MEMO

TO: Nell Donaldson
FROM: Mike Farmer
DATE: April 7, 2015
RE: 195 Kennebec Street – site plan review

PRELIMINARY - NOT FOR CONSTRUCTION

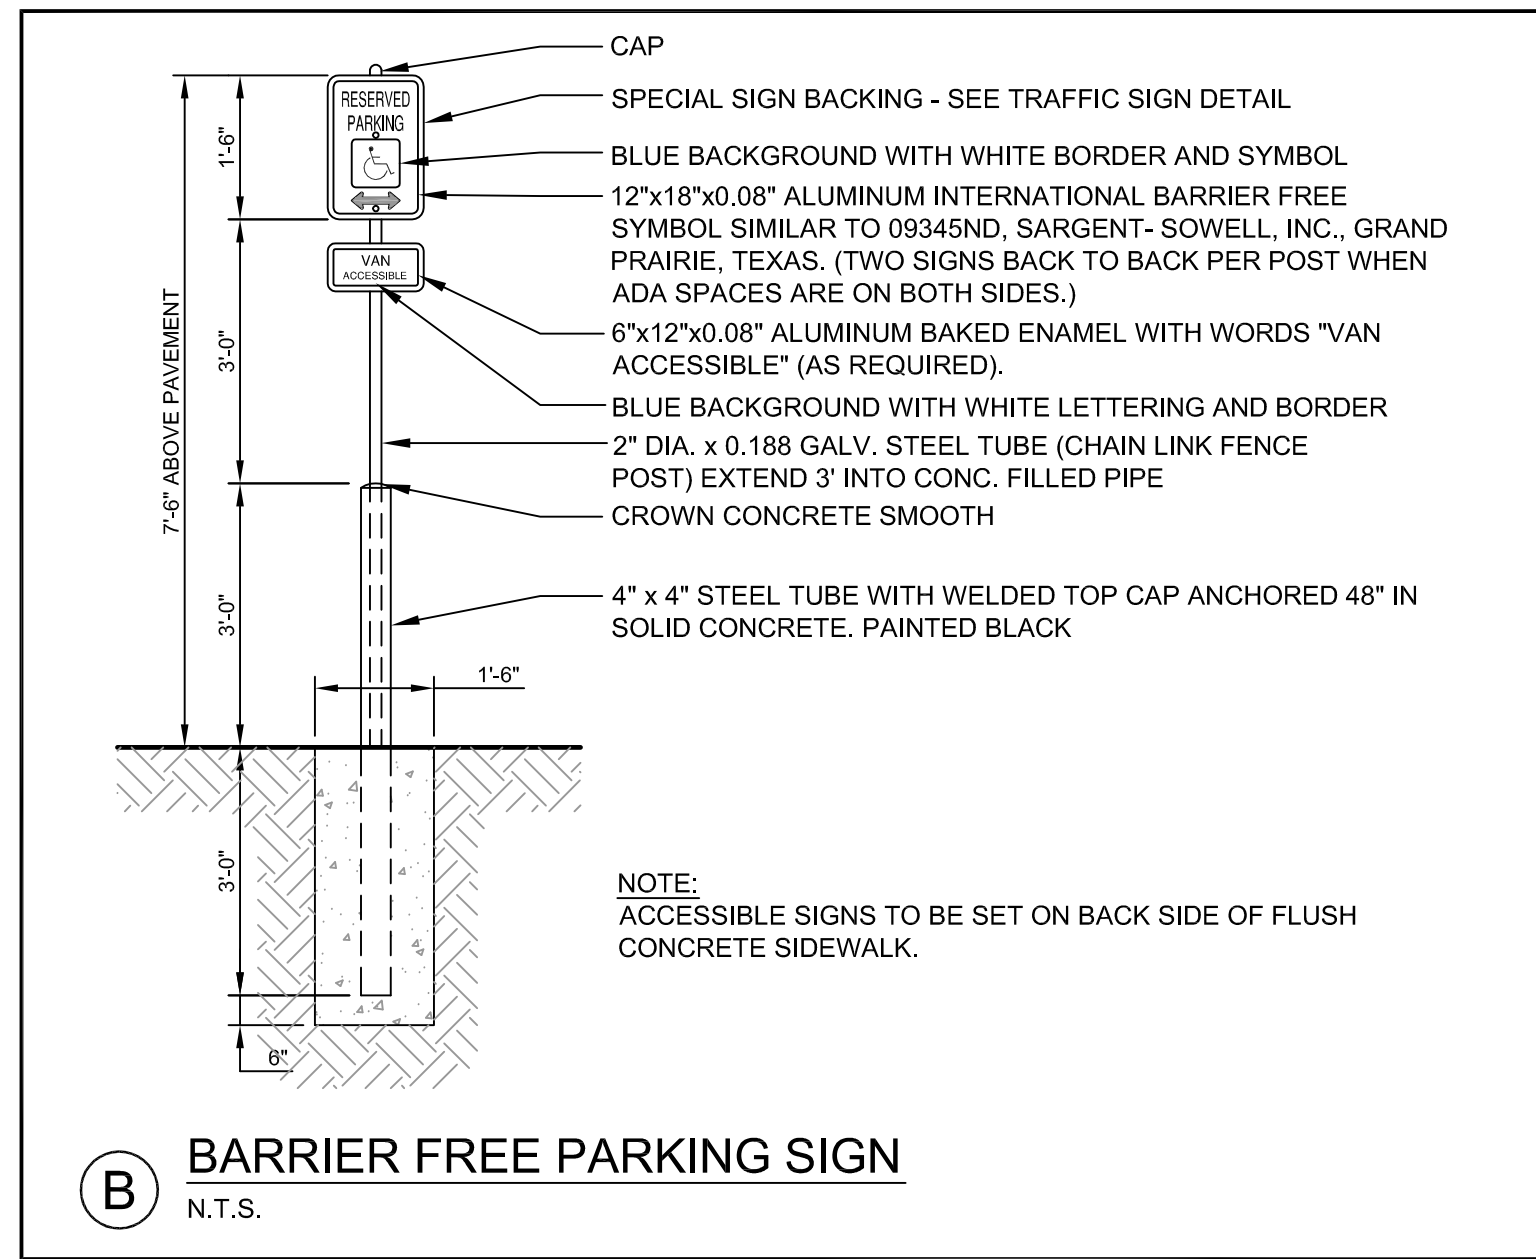
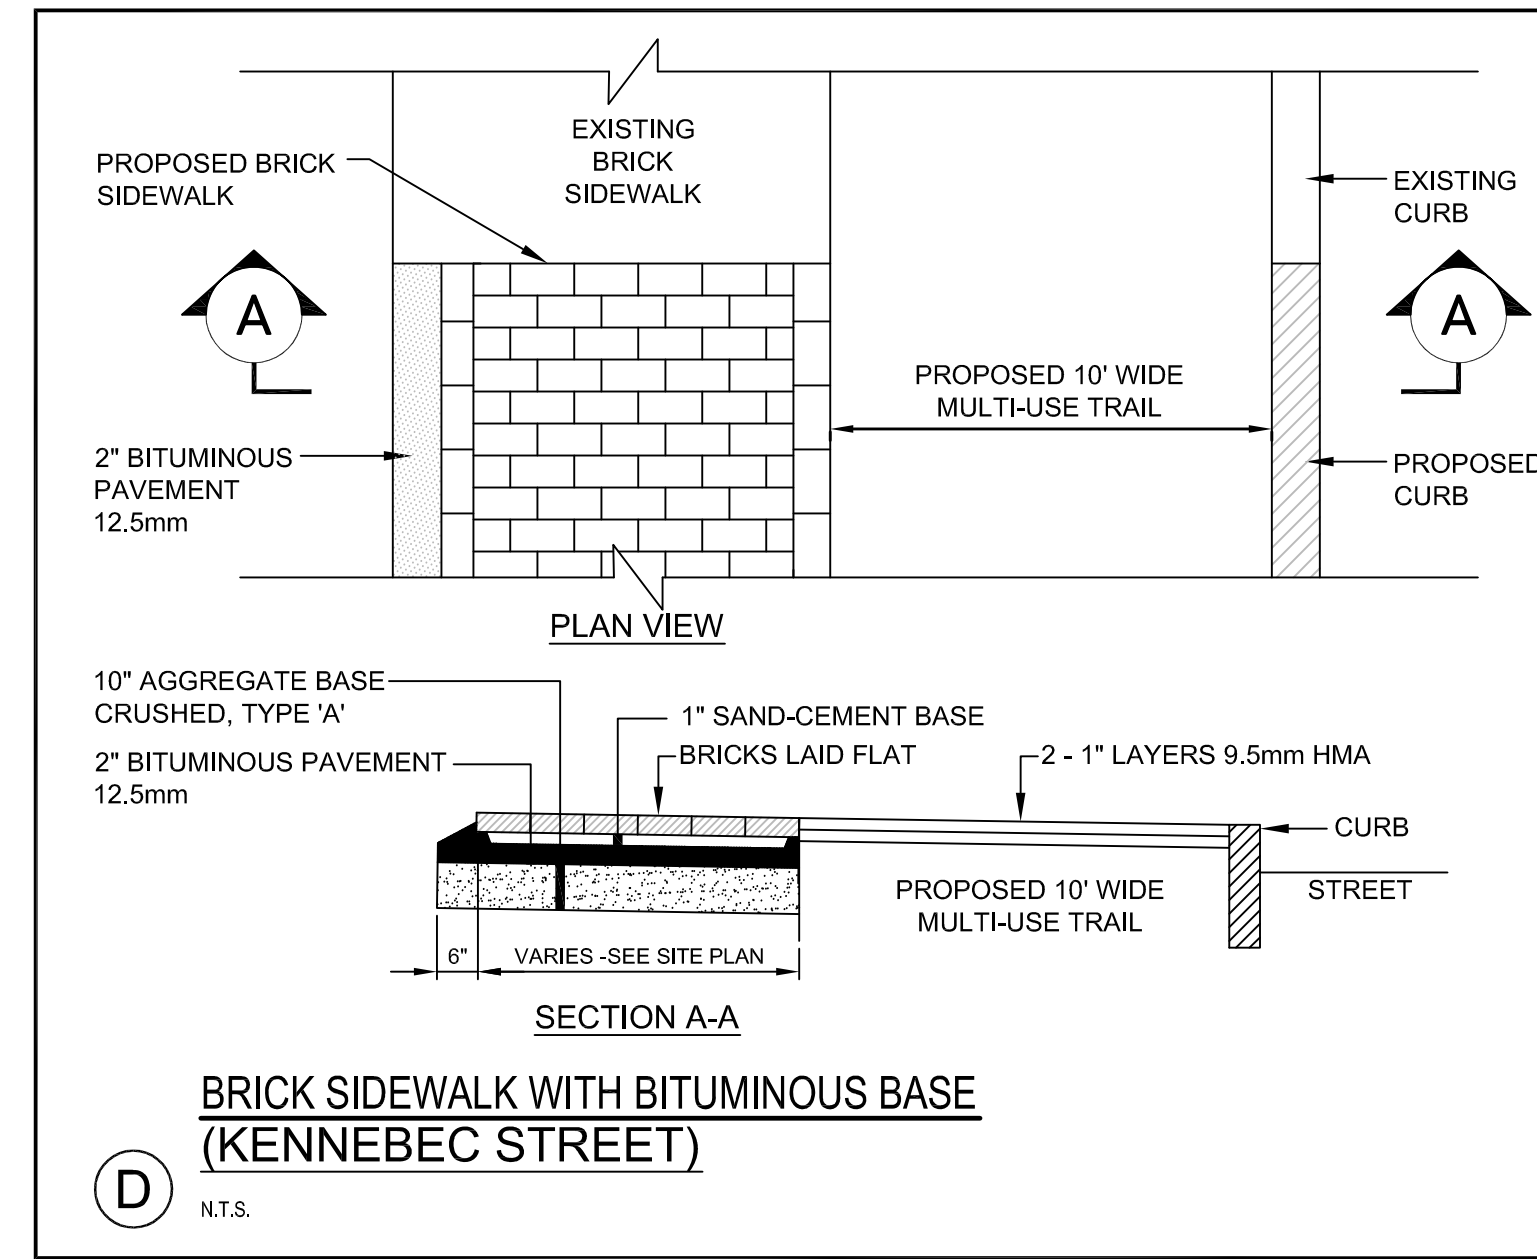
Detail C on plan sheet C-7.0, detail D on sheet C-7.2, and detail E on sheet C-7.2 all should be corrected to show the City standard for depth of base gravel for a brick sidewalk on bituminous base. The depth of gravel should be 10 inches, not 4 inches as indicated in the above referenced details.
